Gatwick Northern Runway

TR020005

National Highways Comments on any Submissions Received by Deadline 5

June 2024

Project Code-Location-Discipline-Volume-Type-Unique Number
41700- XX -B -LLO - GA - 200175

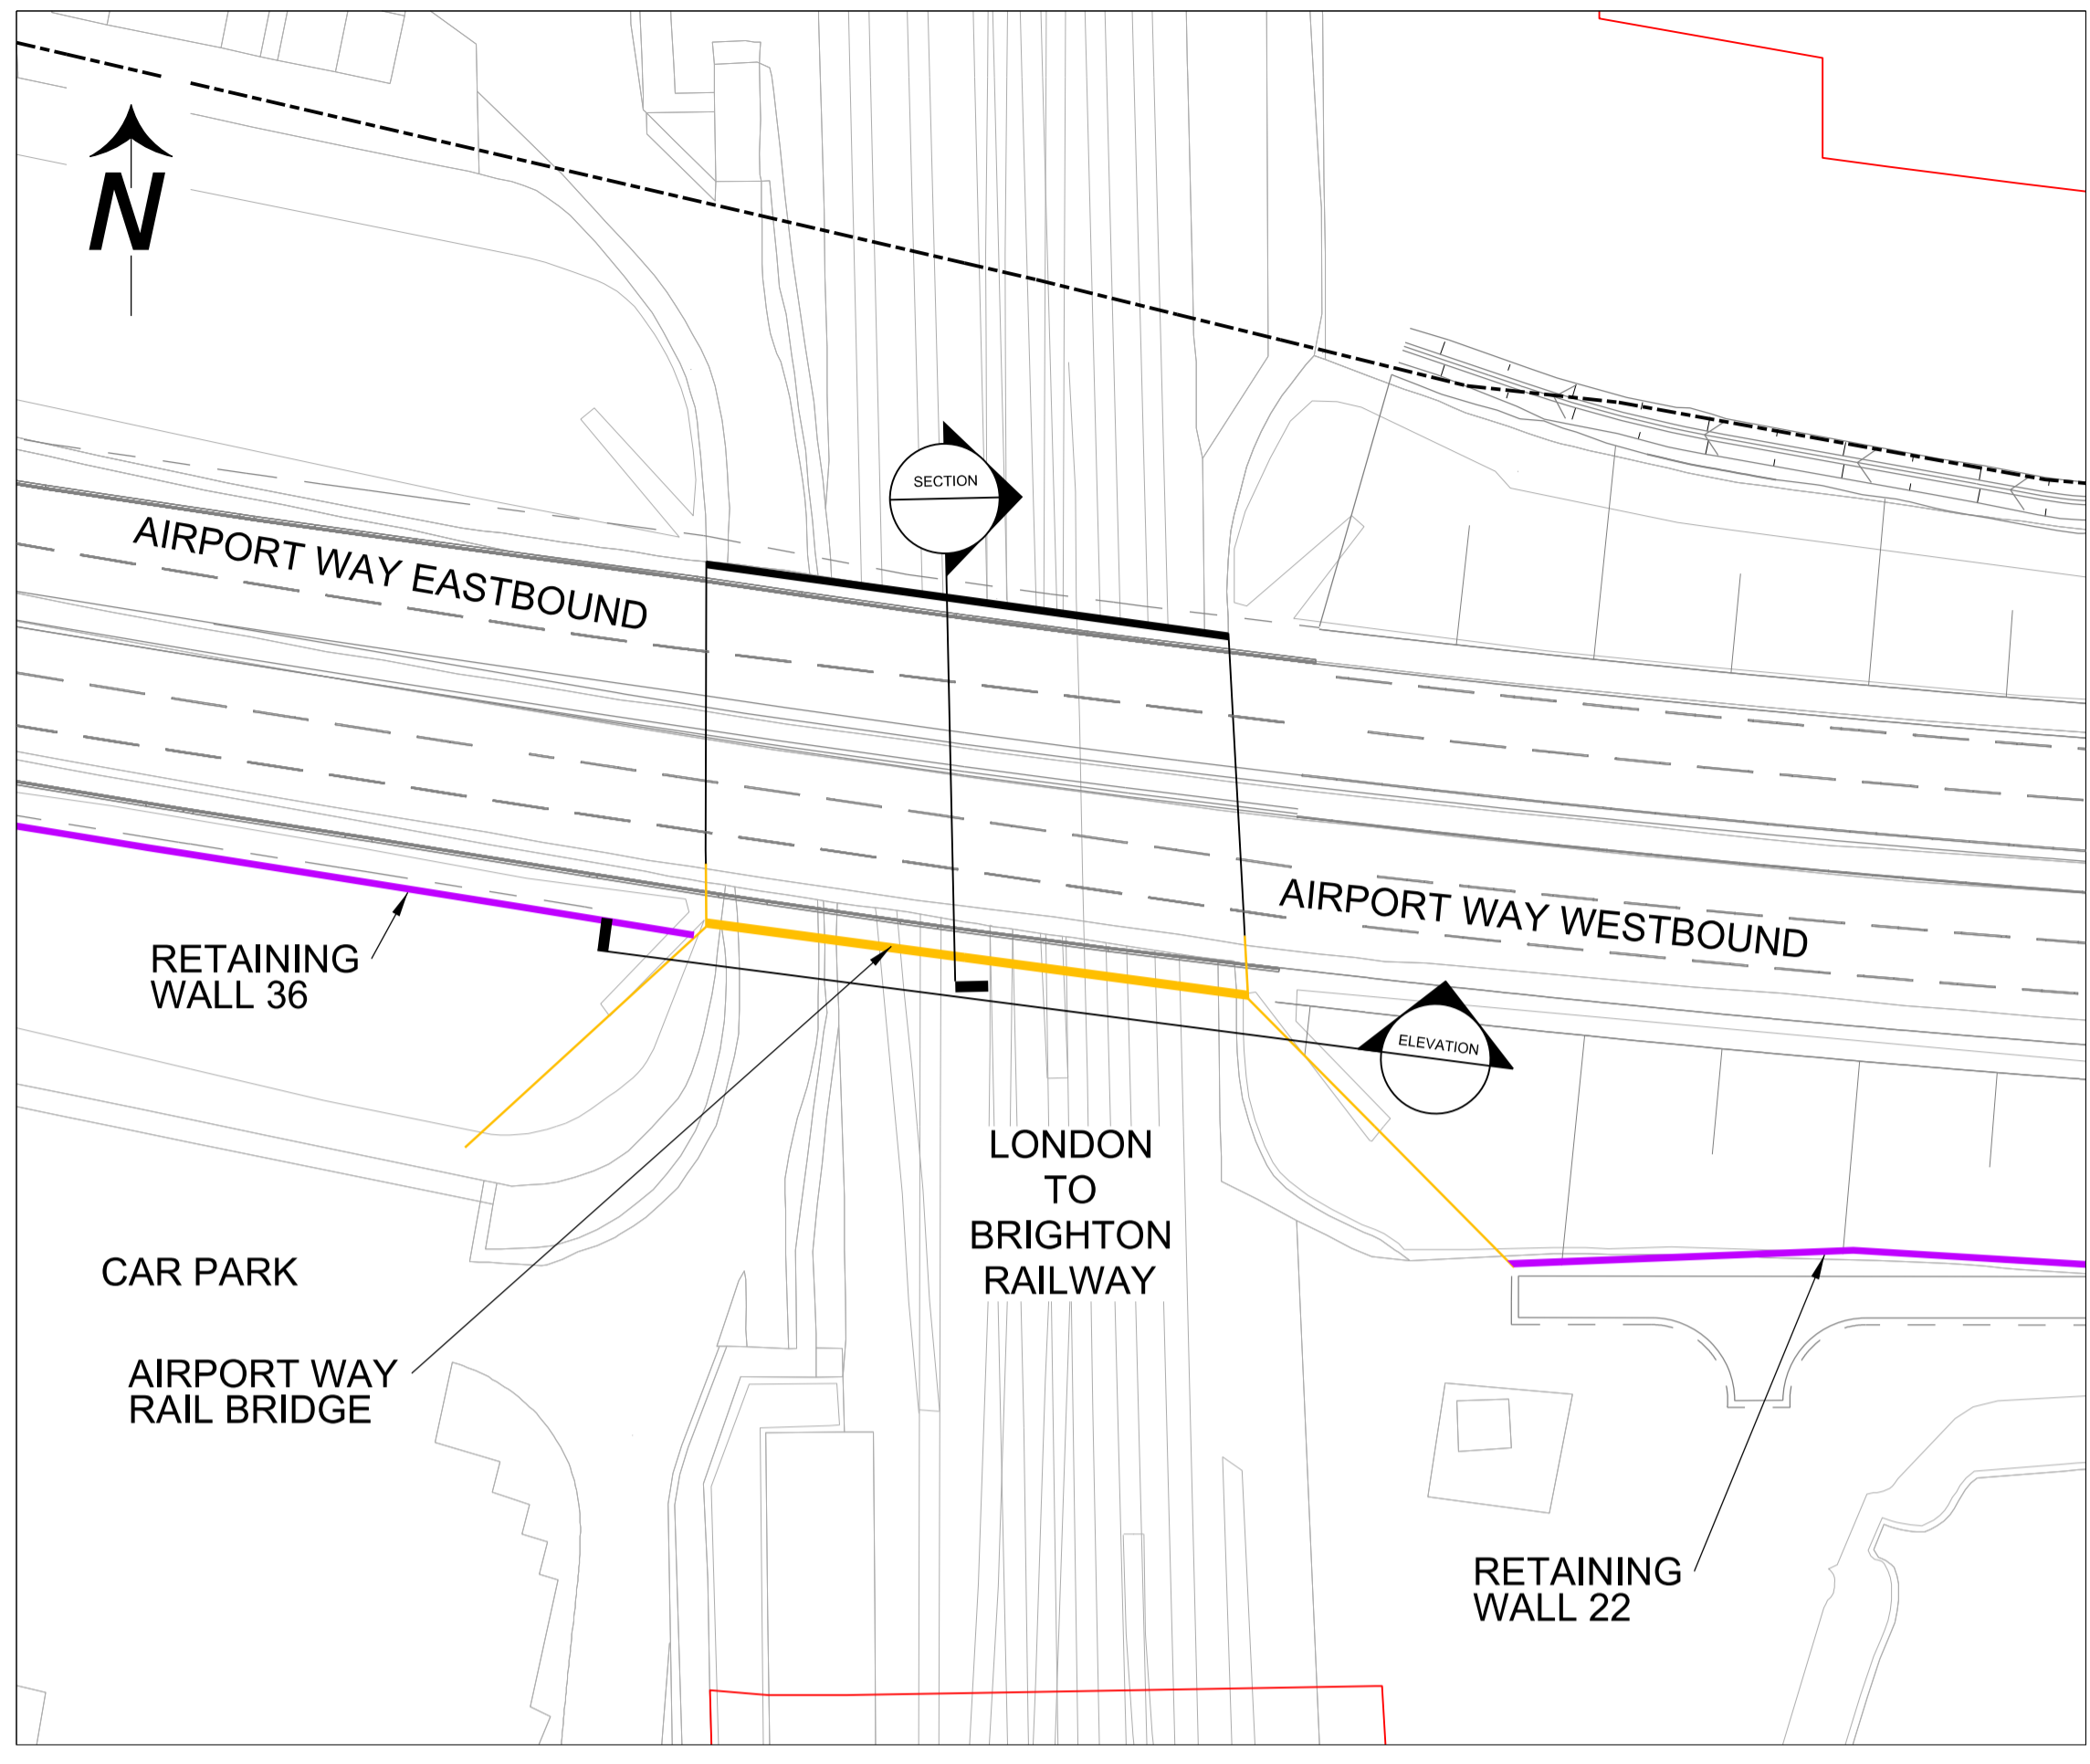
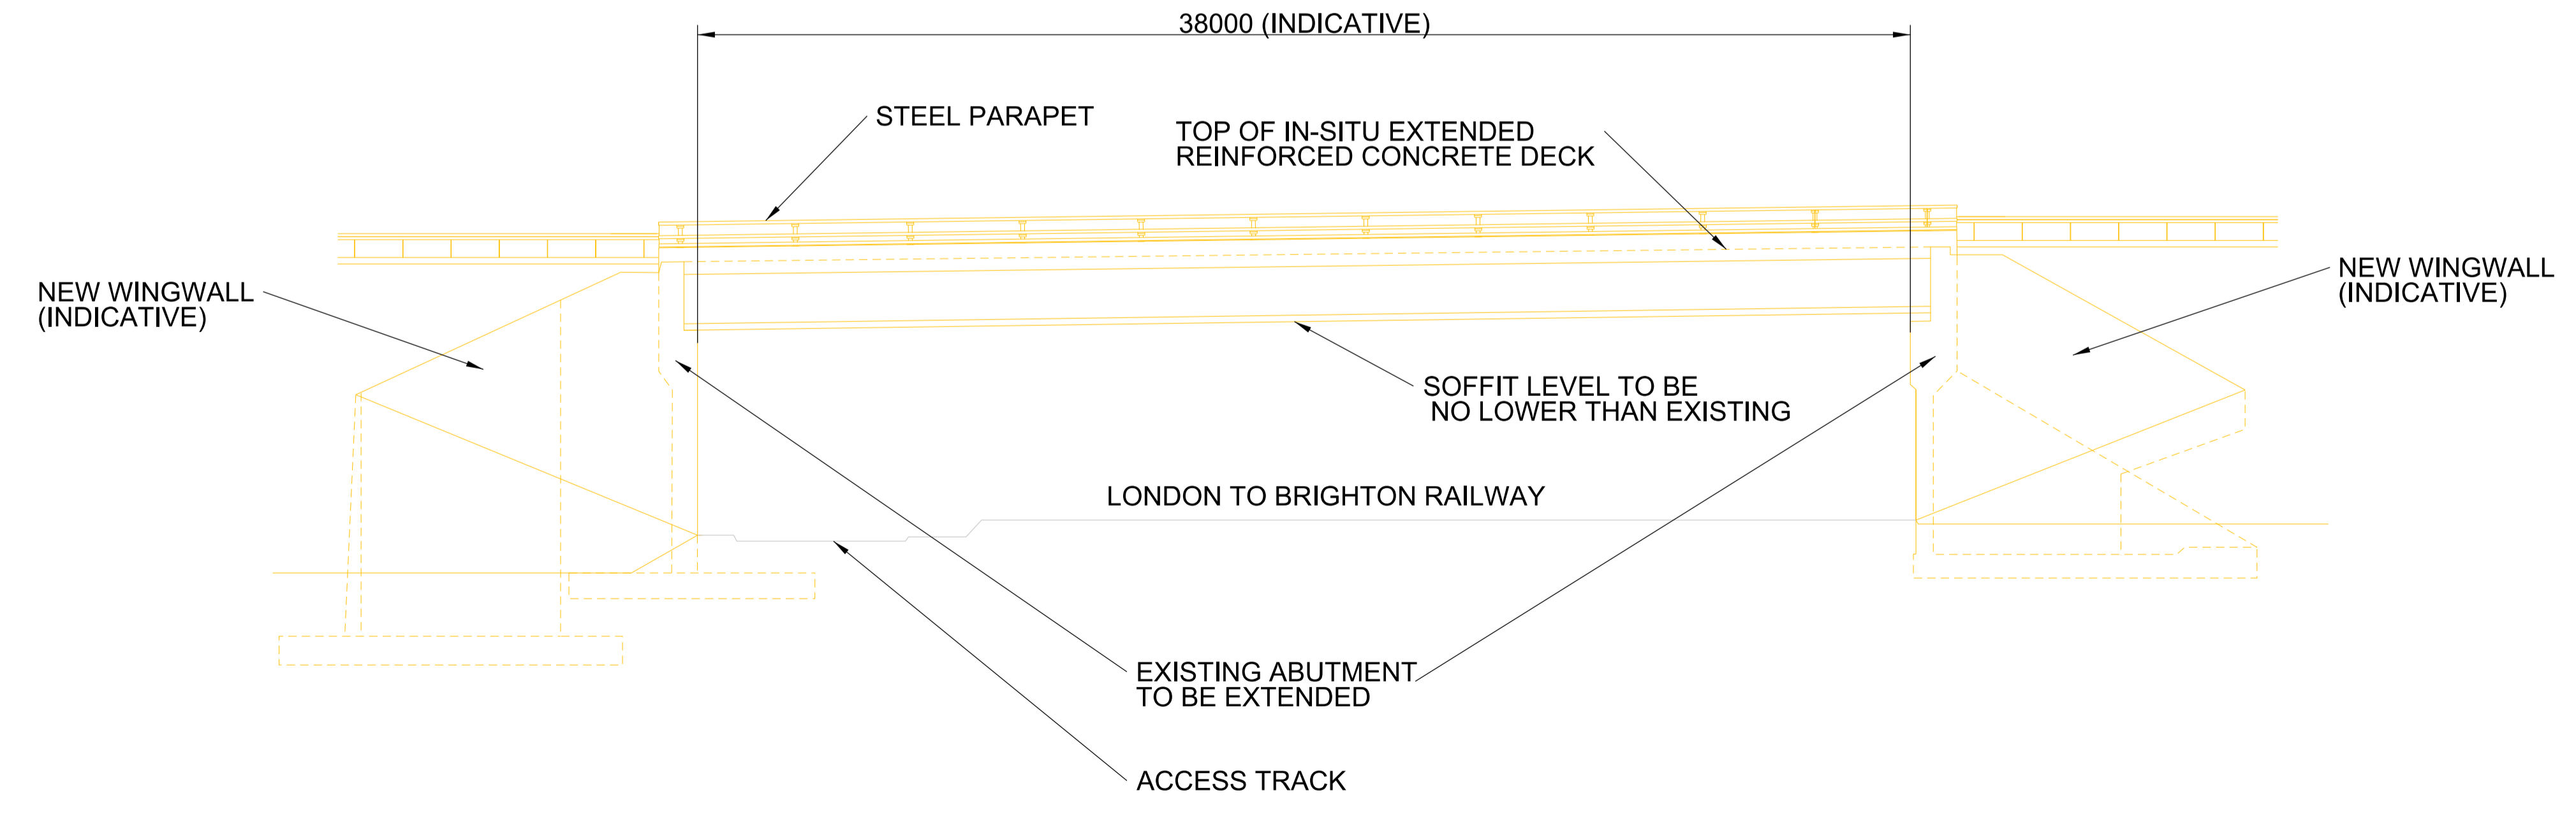
Surface Access Highways Plans – Structure Section Drawings – For Approval - Version 3	REP5-072	<p>Drawing 41700-XX-B-LLO-GA-200175 - For carriageway Section A - A at the proposed North Terminal Flyover bridge and drawing 41700-XX-B-LLO-GA-200178 - For the Gatwick Spur Eastbound carriageway Section C - C at the proposed Balcombe Road bridge, a VRS is provided in front of the noise barrier located within the verge. This infrastructure can be accessed for maintenance from the verge side and therefore no maintenance activities are considered to be required to the rear of the noise barrier and no edge restraint system has been proposed on the parapet edge beam as this itself would require maintenance next to the retaining wall vertical face.</p> <p>This cross-section edge detail will be subject to ongoing development through detailed design. At this stage based on the feedback received from NH, it is envisaged that the structural plinth would be relocated in line with the proposed noise barrier reducing the overall cross-section width of the Gatwick Spur Balcombe Road bridge and North Terminal Flyover bridge. This could be achieved within the scheme limits of deviation and it is proposed that this would be finalised and agreed at the detailed design stage (with an action recorded as part of SoCG discussions), noting the protective provisions in place for NH with respect to detailed design approvals.</p>	National Highways acknowledges the response by the Applicant and therefore reserves the right to engage with the Applicant during detailed design to ensure that any alterations to address this matter meet the standards and requirements of the DMRB.
